The revised route and positioning of the pylons came as a substantial shock to E R Ling & Sons Limited as their land was well east of the initial preferred route. The business was not even informed of the drastic realignment towards Palgrave until it was made available in the public domain, which is totally unacceptable given the scale of the impact and burden that National Grid (NG) are now proposing to place on the land and business that operates over it.

Proposed route amendments- ignored to date-

Yellow line = suggested new route

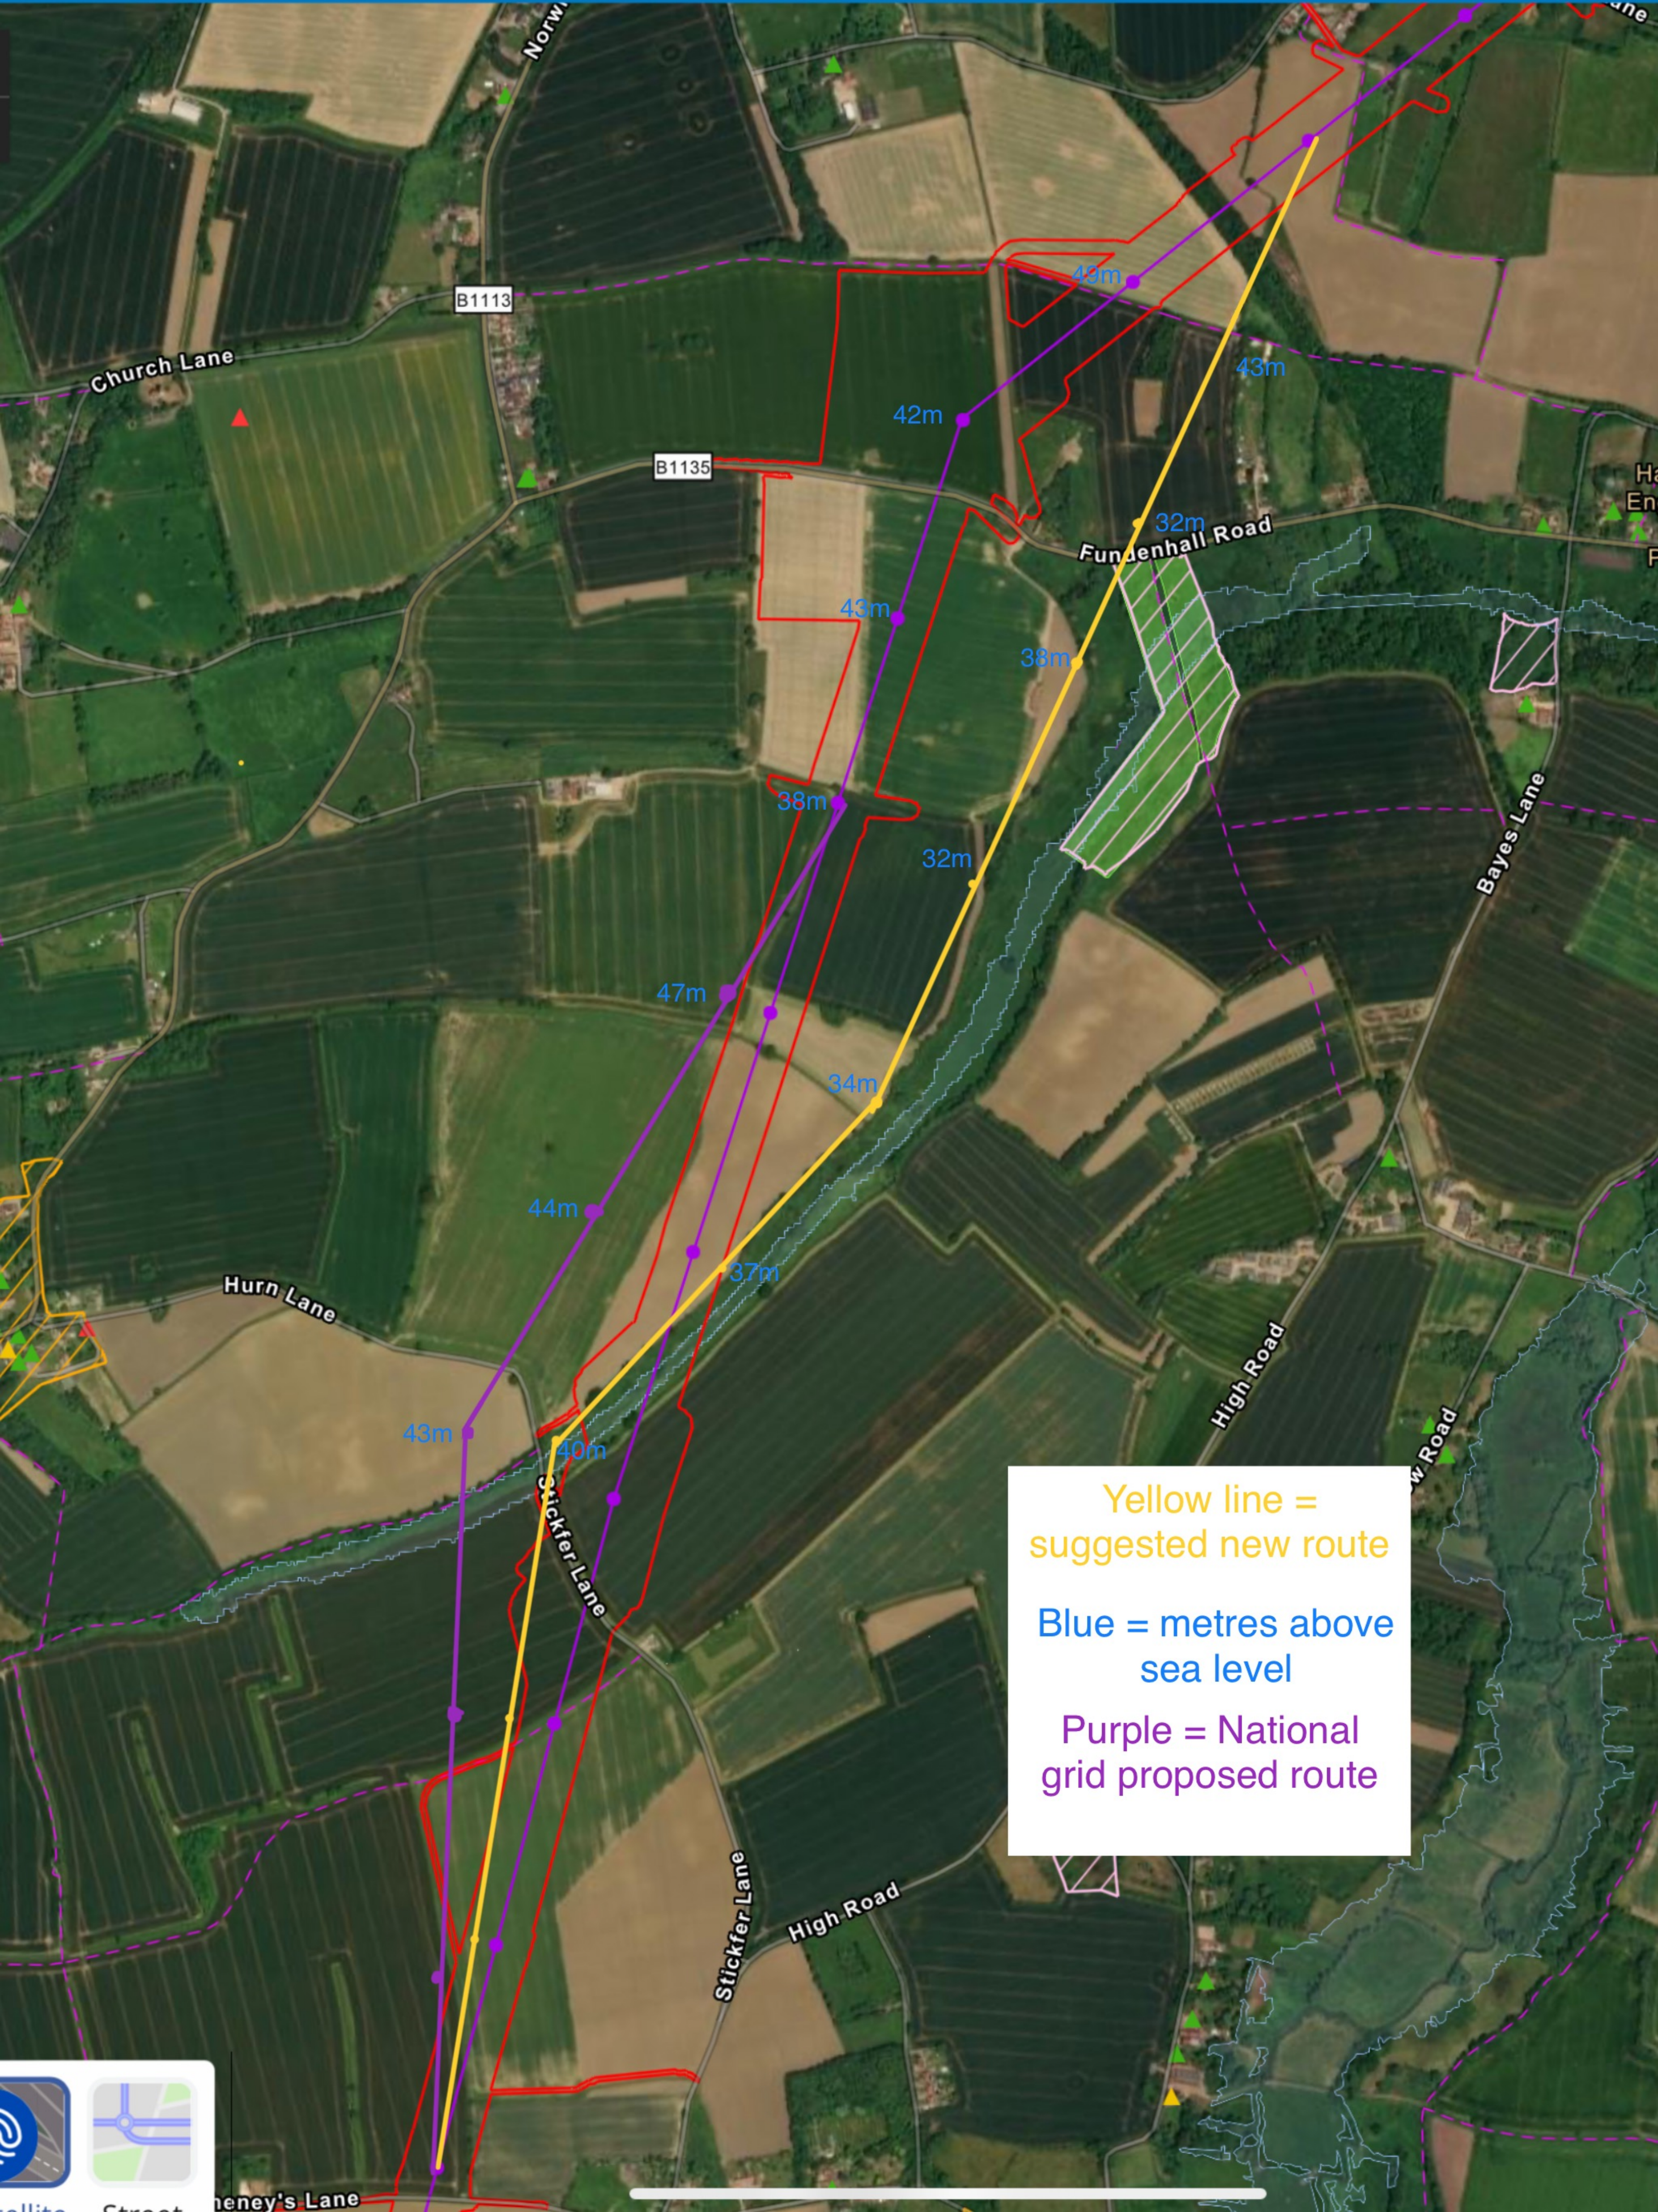
RG093 - move West to field boundary and to avoid solar scheme now under construction

RG094 - Move North into meadow- into smaller less productive field with improved natural screening.

RG095 move west to field boundary to avoid interruption to arable farming operations and to avoid blighting site for farm yard expansion.
